**Subject:** 2026/90938 at location land at, Hanging Stone Road, Berry Brow, Huddersfield, HD4 7QU

Please see ecological commentary below:

TITLE
EXISTING SITE PLAN

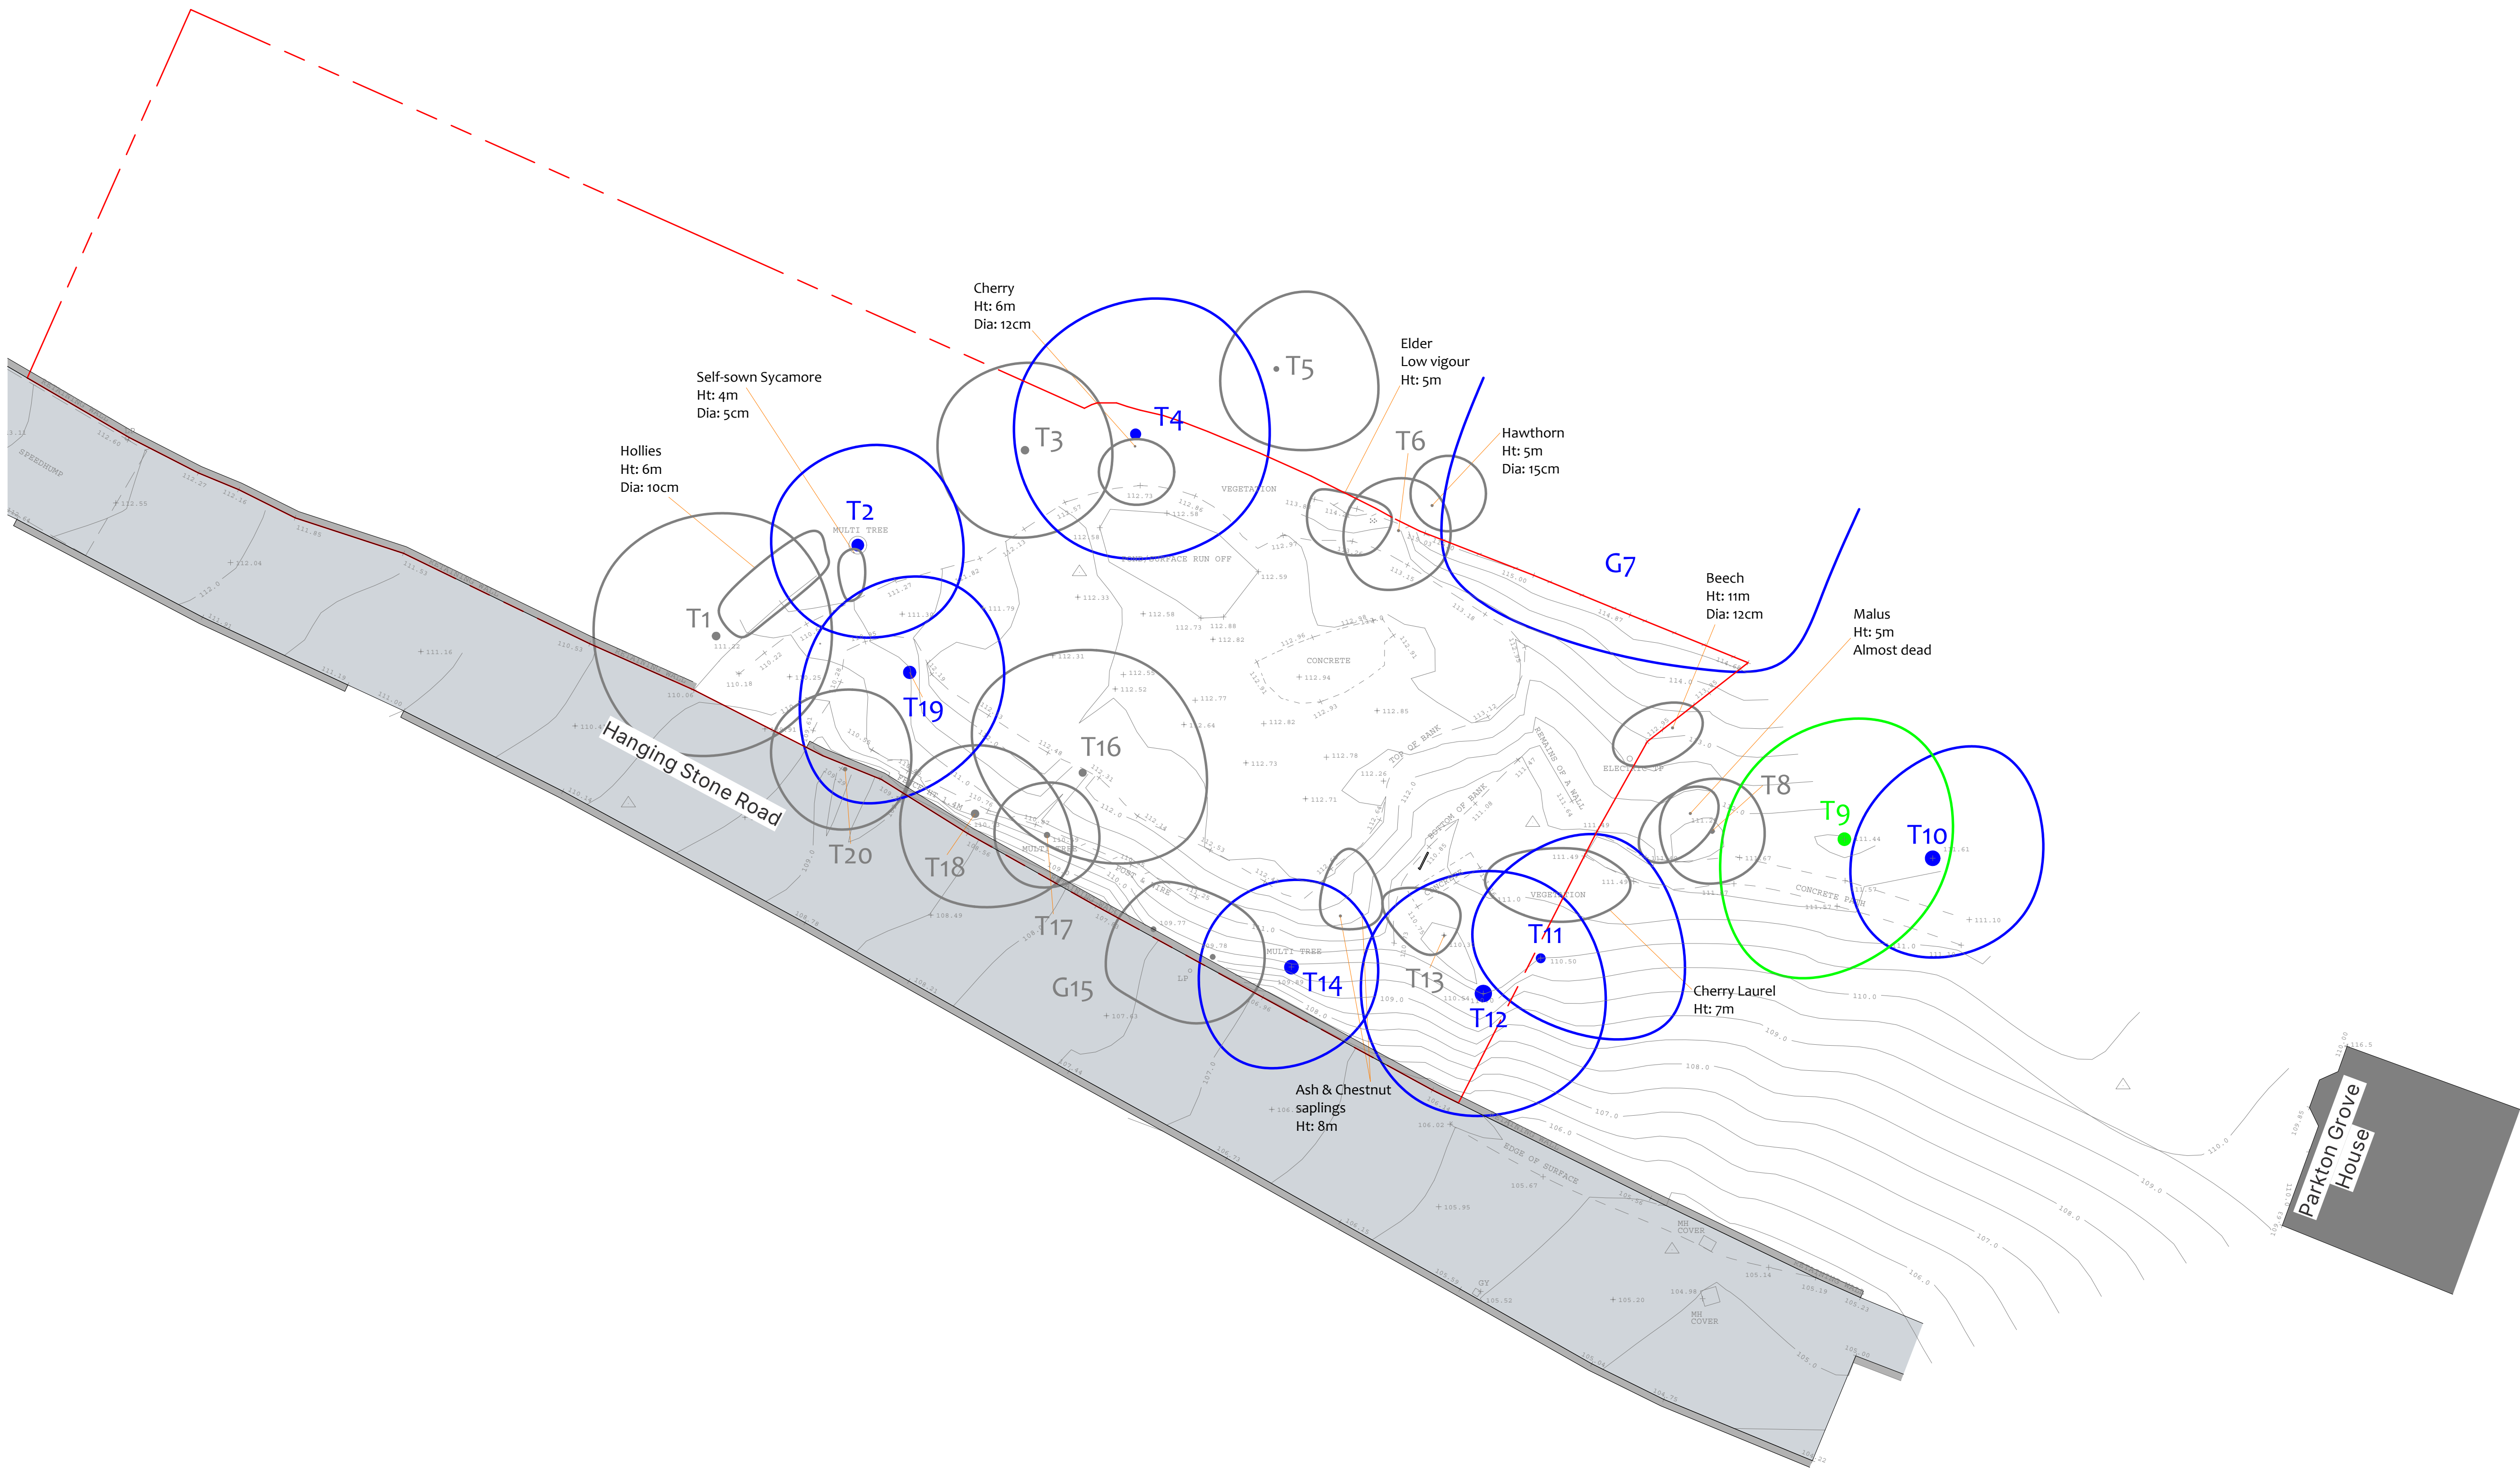
- GCN – there is a pond onsite – which is to be lost to the development. An eDNA survey was conducted and returned a positive result, indicating that GCN could be using the site. Further surveys will need to be conducted prior to determination in order to assess the population onsite and ascertain if a licence is required.

- GCN surveys to be completed prior to determination
- Please can the design be reviewed to maintain the pond?
- Given the priority habitats and SSSI within proximity to the site, and that the site has designated priority habitat / is within the Kirklees Wildlife Network – it is advised that Natural England are consulted over any concerns they may have about the development.
